**From:** Richard Peppe <pepperwjr@aol.com>  
**Sent:** Thursday, June 19, 2025 10:05 AM  
**To:** Michelle F. Myatt  
**Cc:** Dick Peppe; Maggie Peppe  
**Subject:** Re: Business License Number for Site Built Sheds  
**Attachments:** Owner Affidavit.pdf

Sorry for the delayed answer to the engineers questions concerning the garage bill. Been out of town the last week due to real estate transactions.

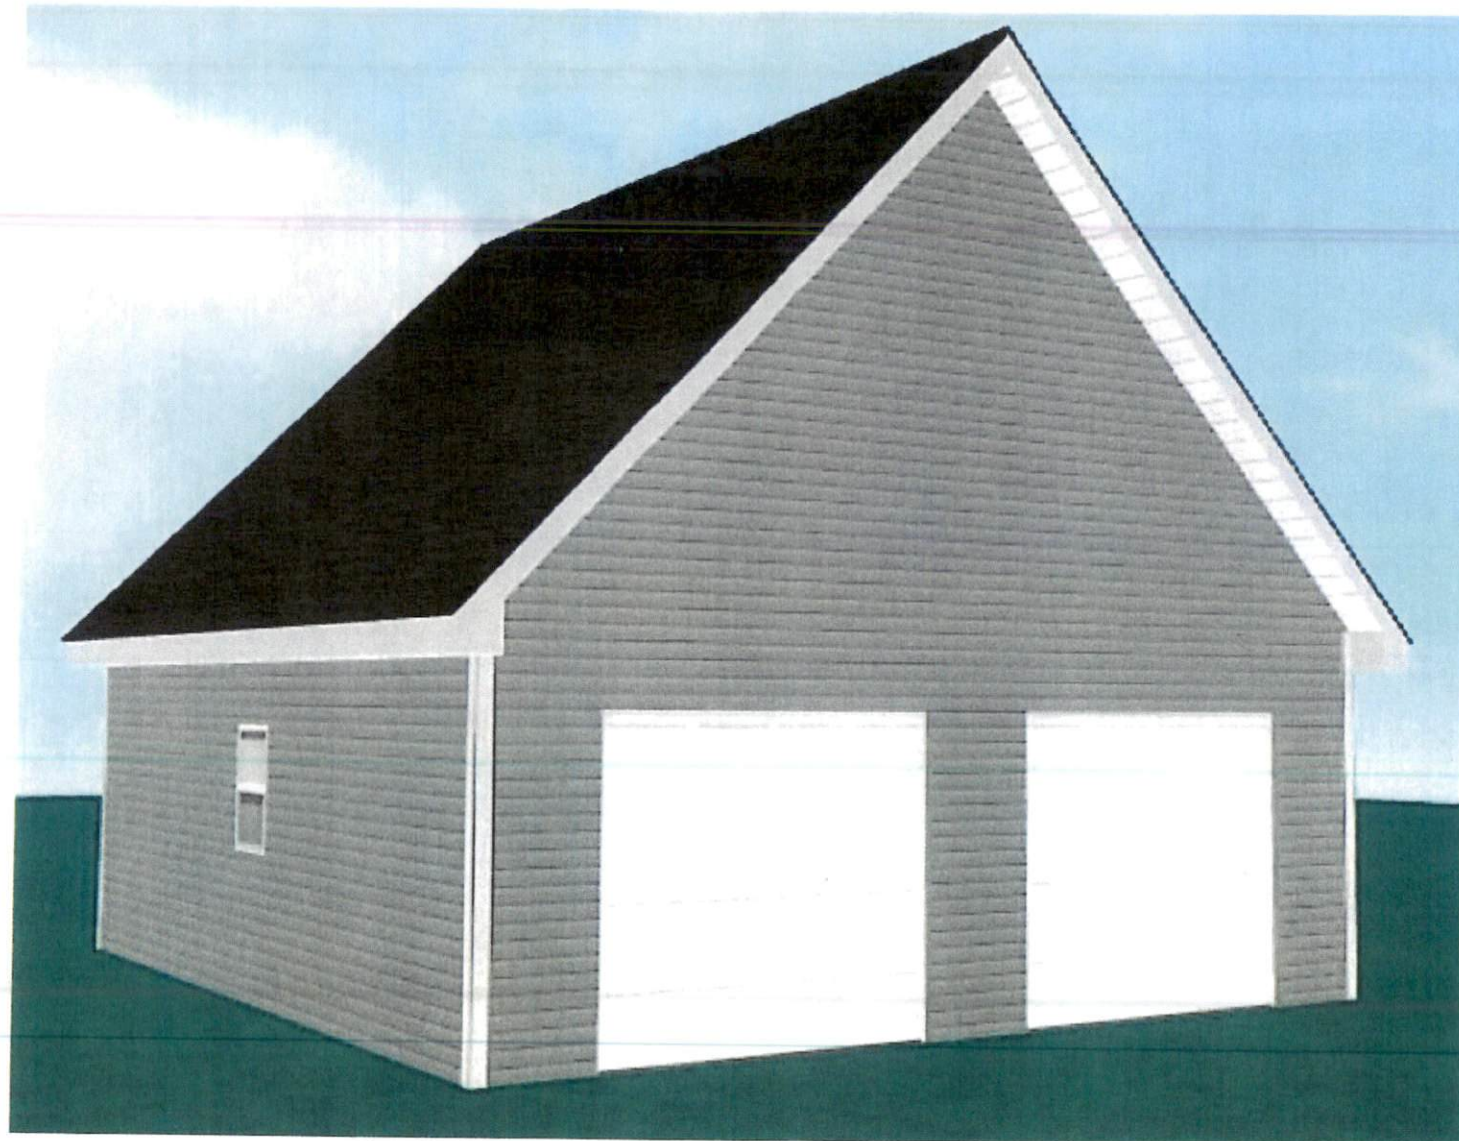
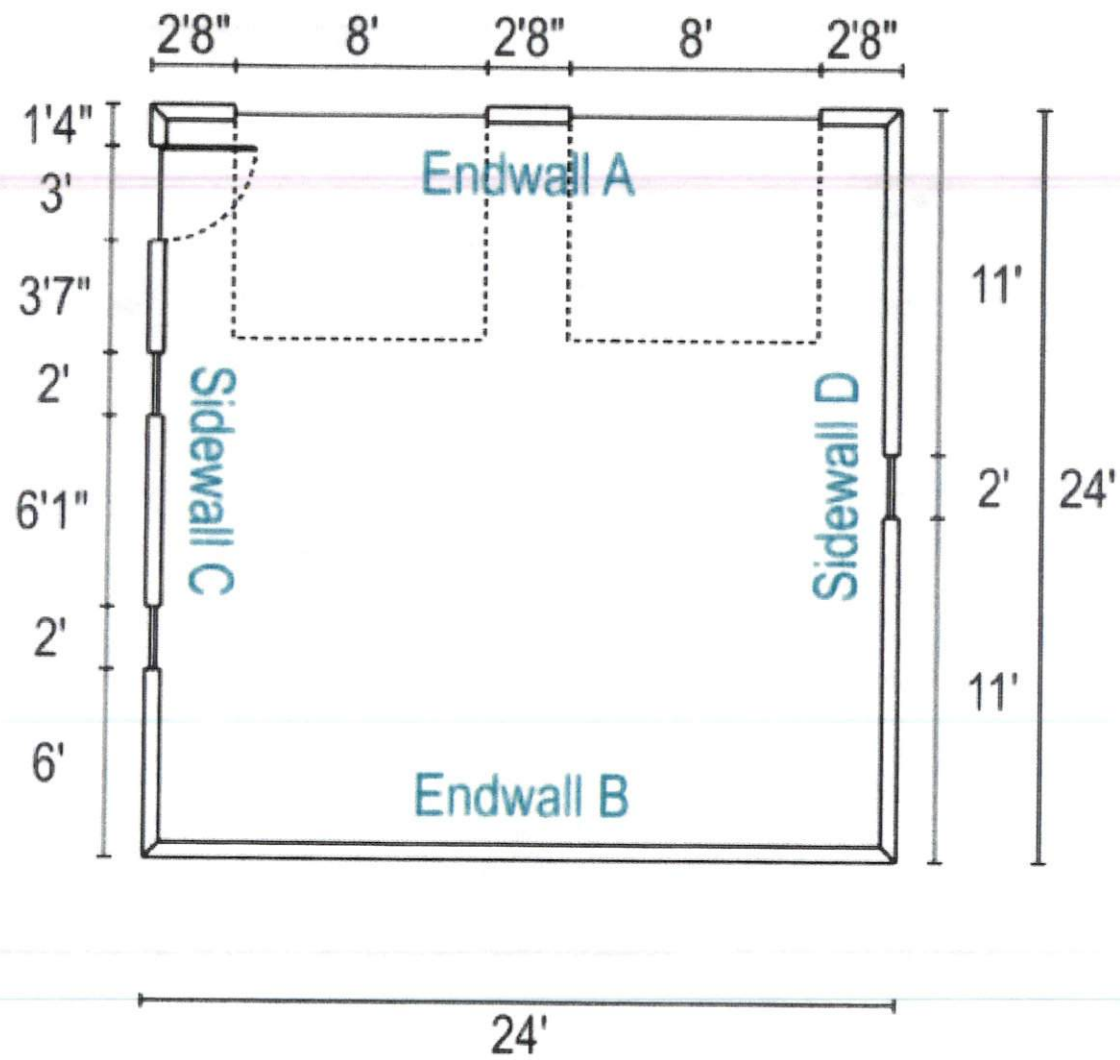
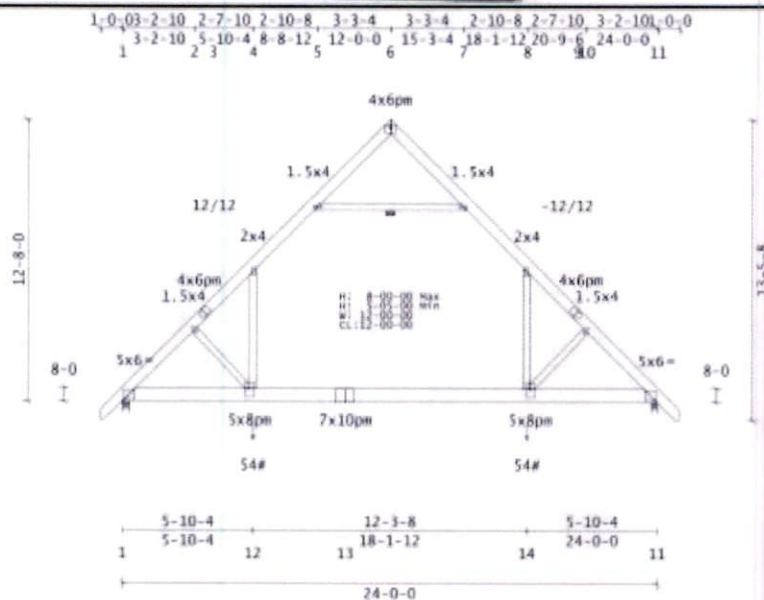
1. What is going to be stored on the second floor space of the garage?

The only things that will be stored on the second floor will be my wife's Christmas decorations. These are very light containers ranging from Christmas, easter, July 4th, etc.
